**Outline application with some matters reserved for demolition of existing detached dwelling
& erection of 2 no. 5 bed dwellings, double garage & alterations to existing access
69 Coastal Road, Kingston**

I regret that I am unable to accept your documents as a formal application until the following matters have been resolved :-

Rev A: Windows to bedroom/fairly corrected				Nov 2011	
REVISION					
PROJECT					
Proposed development at 'Simcar' Coastal Road, East Preston					
SUBJECT					
Plot 2 - Indicative Plans and Elevation					
SCALE		DATE		DRAWING No	
1:100		Nov 2011			
DRAWN		CHECKED			
11 / 46 / 03				Rev A

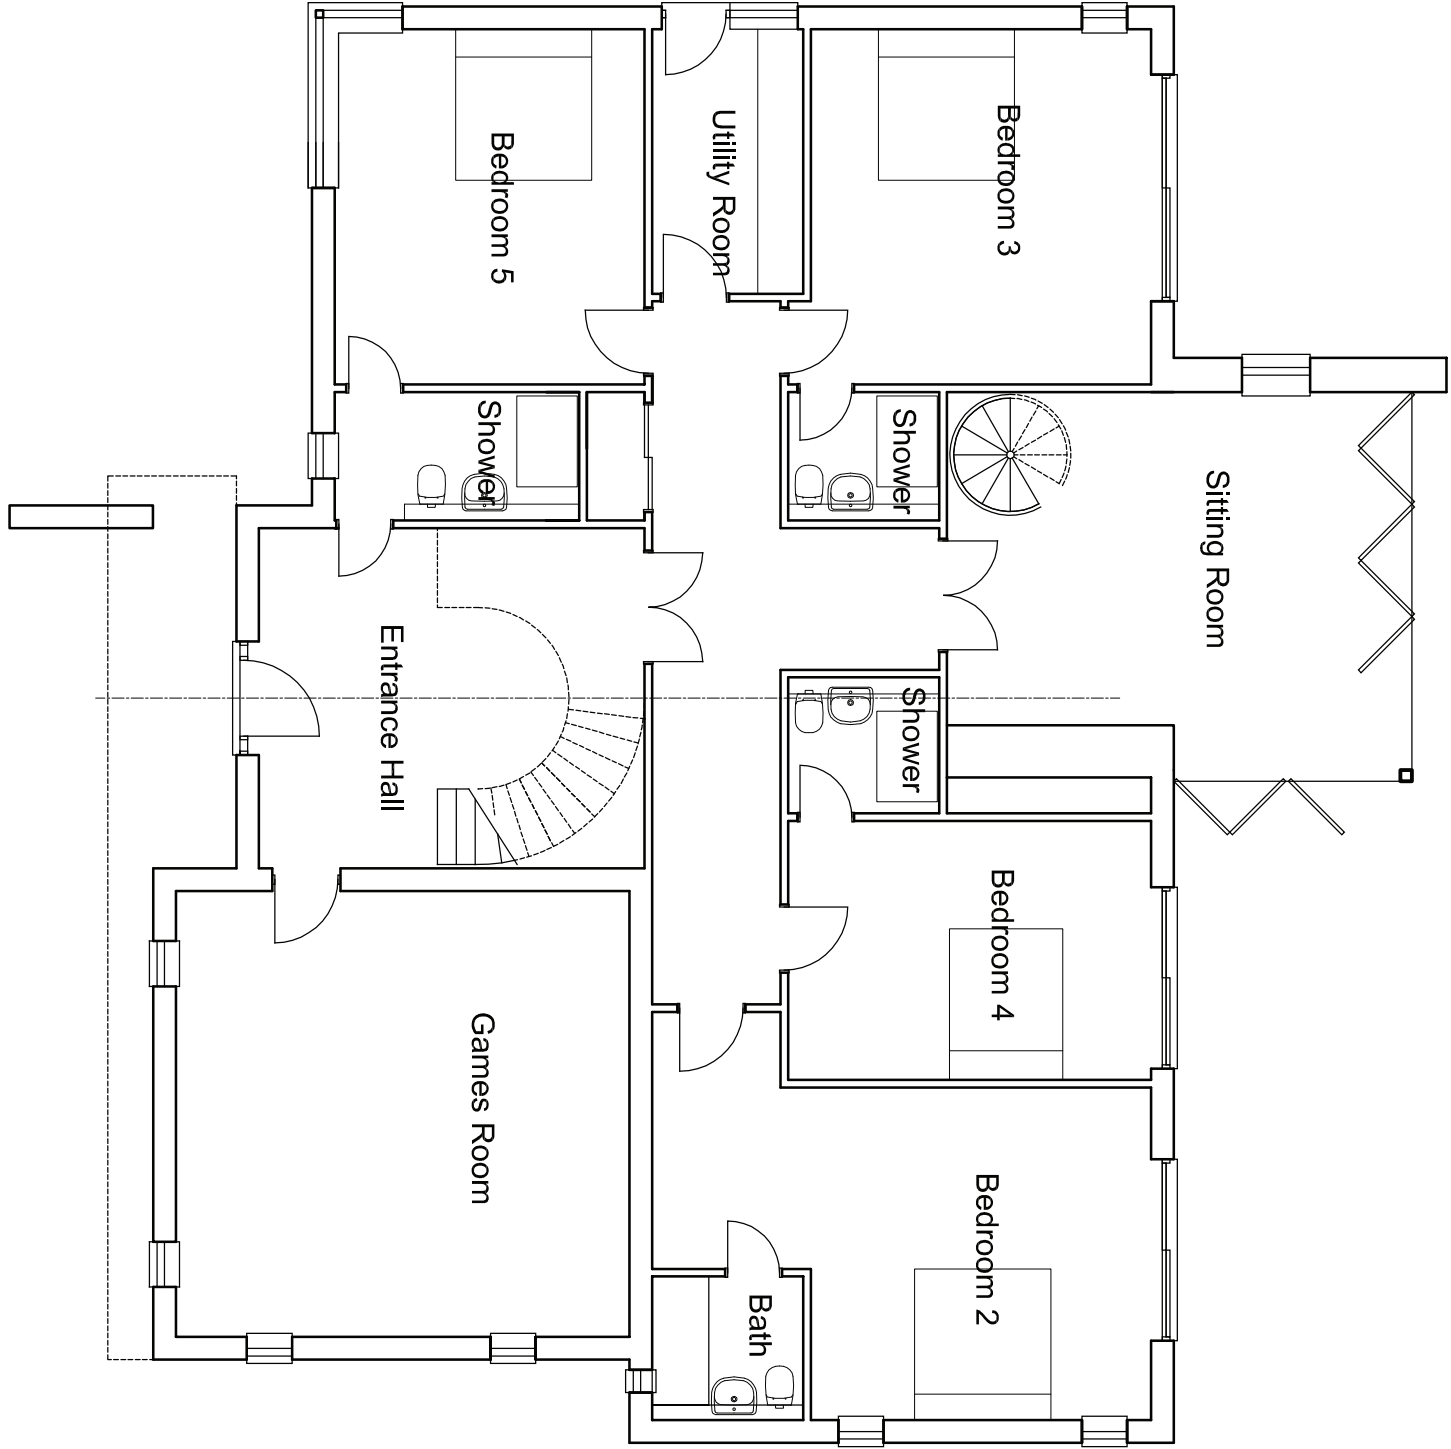
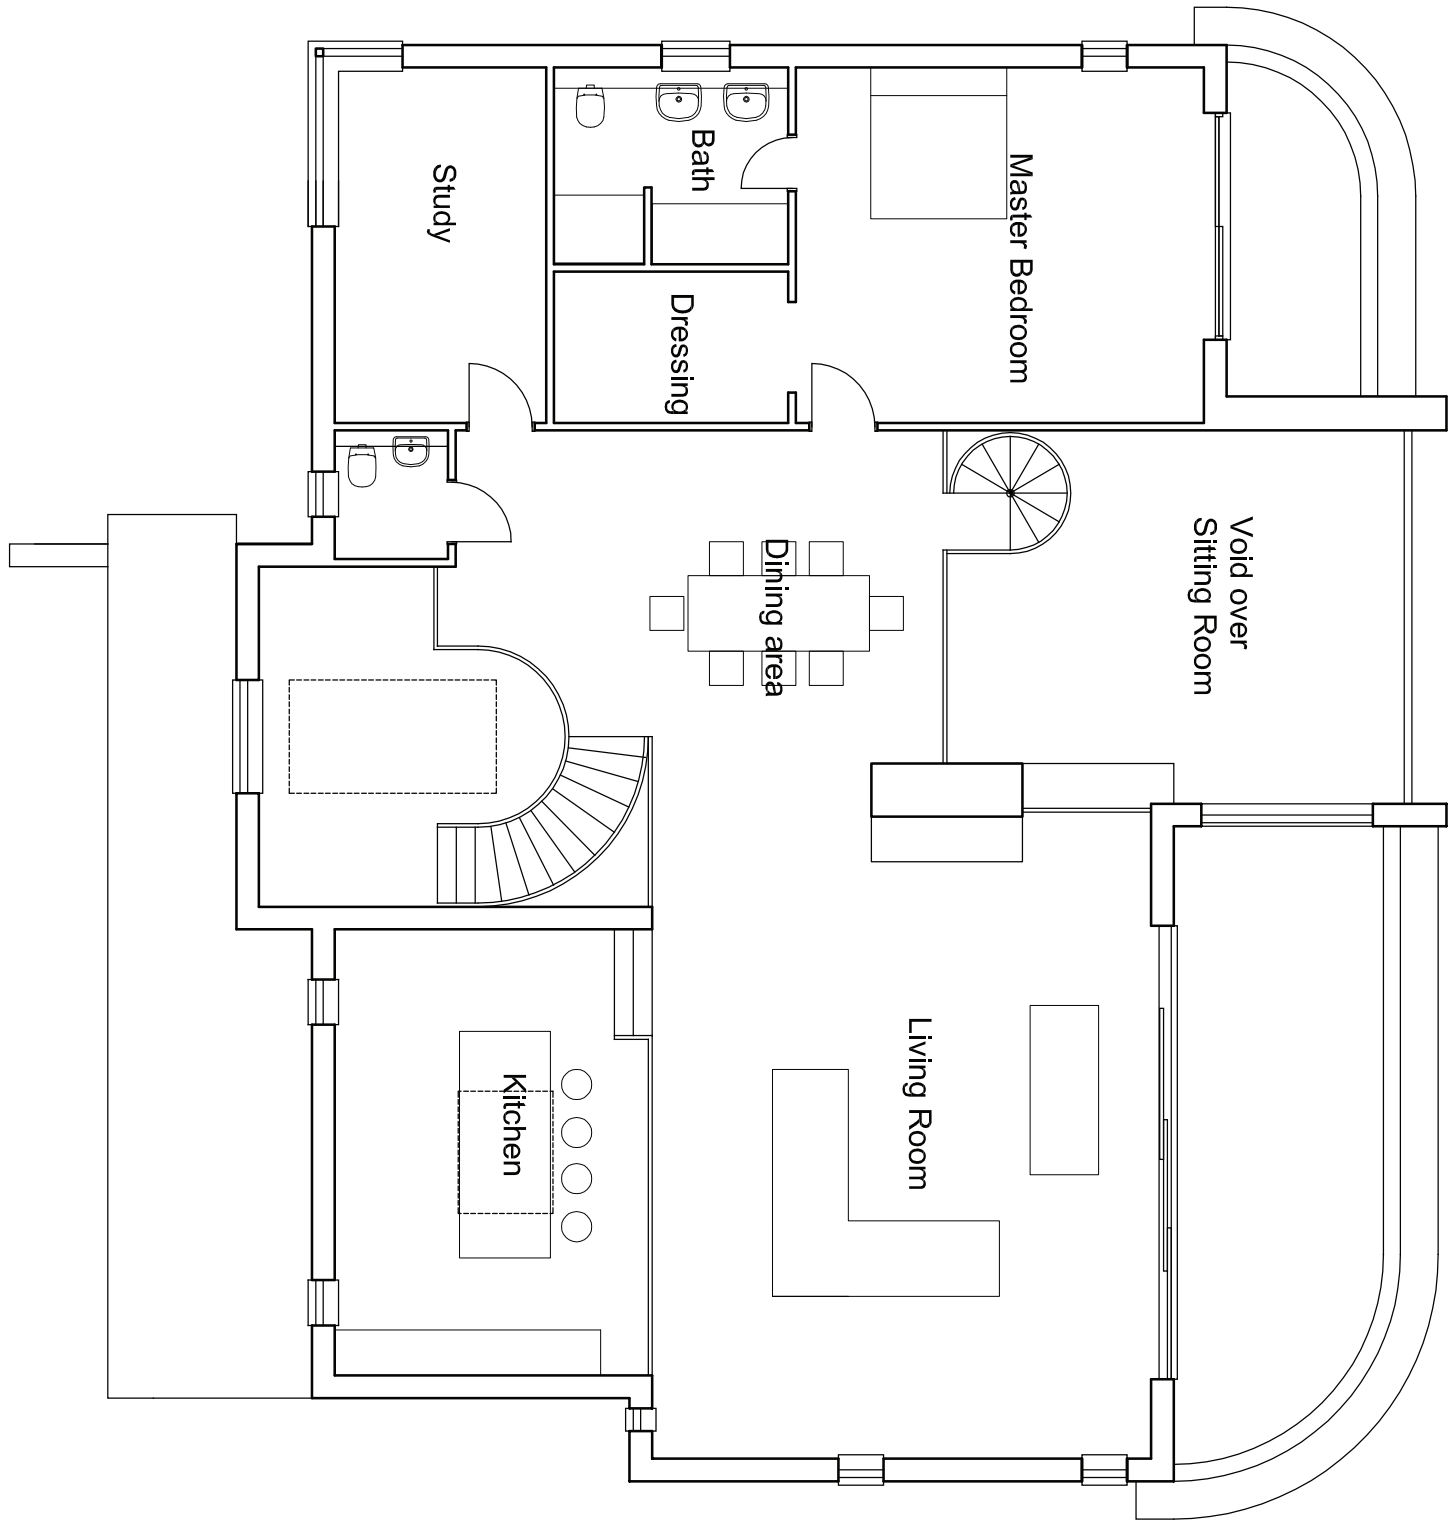
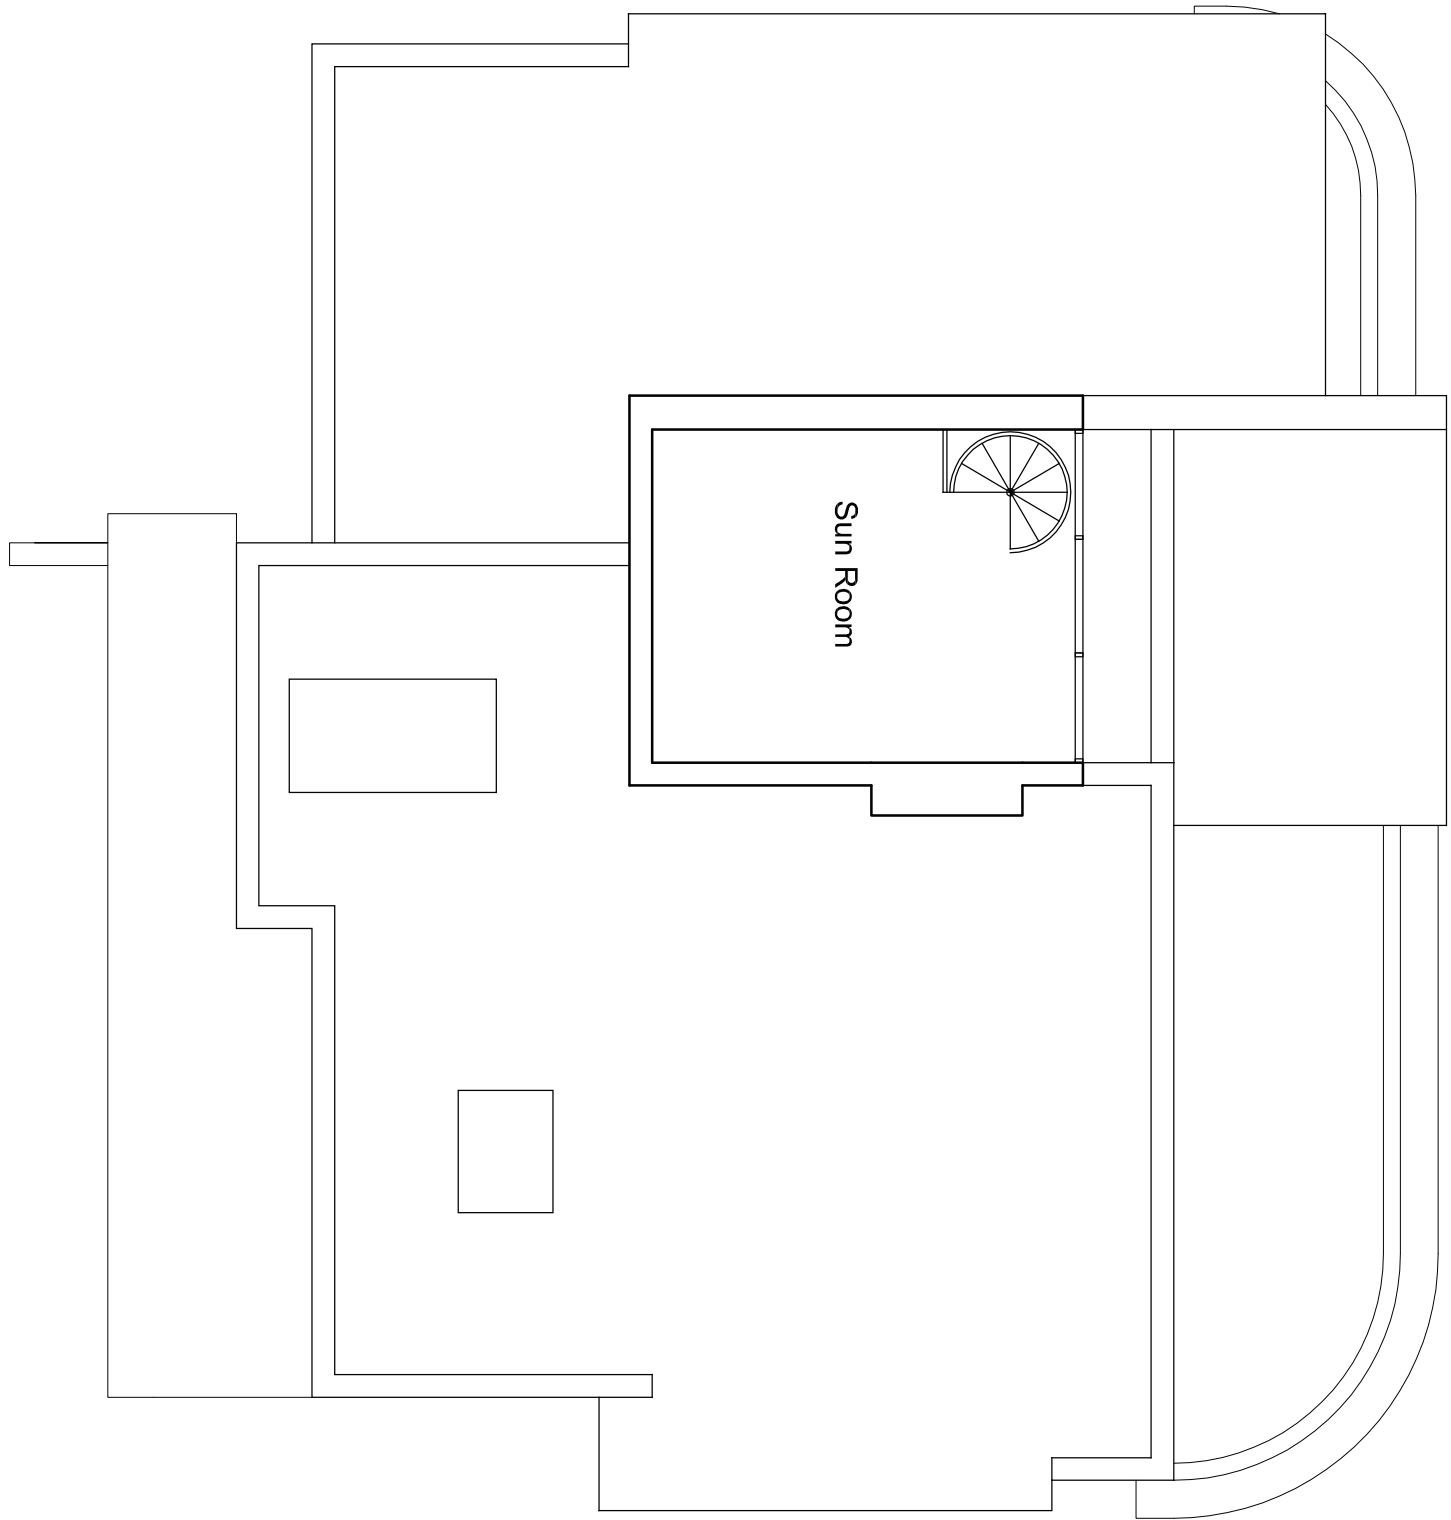
Please provide 1 electronic or 3 paper copies of a revised plan (drawing no. 11/46/03). There are windows shown on the ground floor and first floor plans (bedroom 5/study) which do not match the windows shown on the north elevation (Plot 2). Please amend. ✓
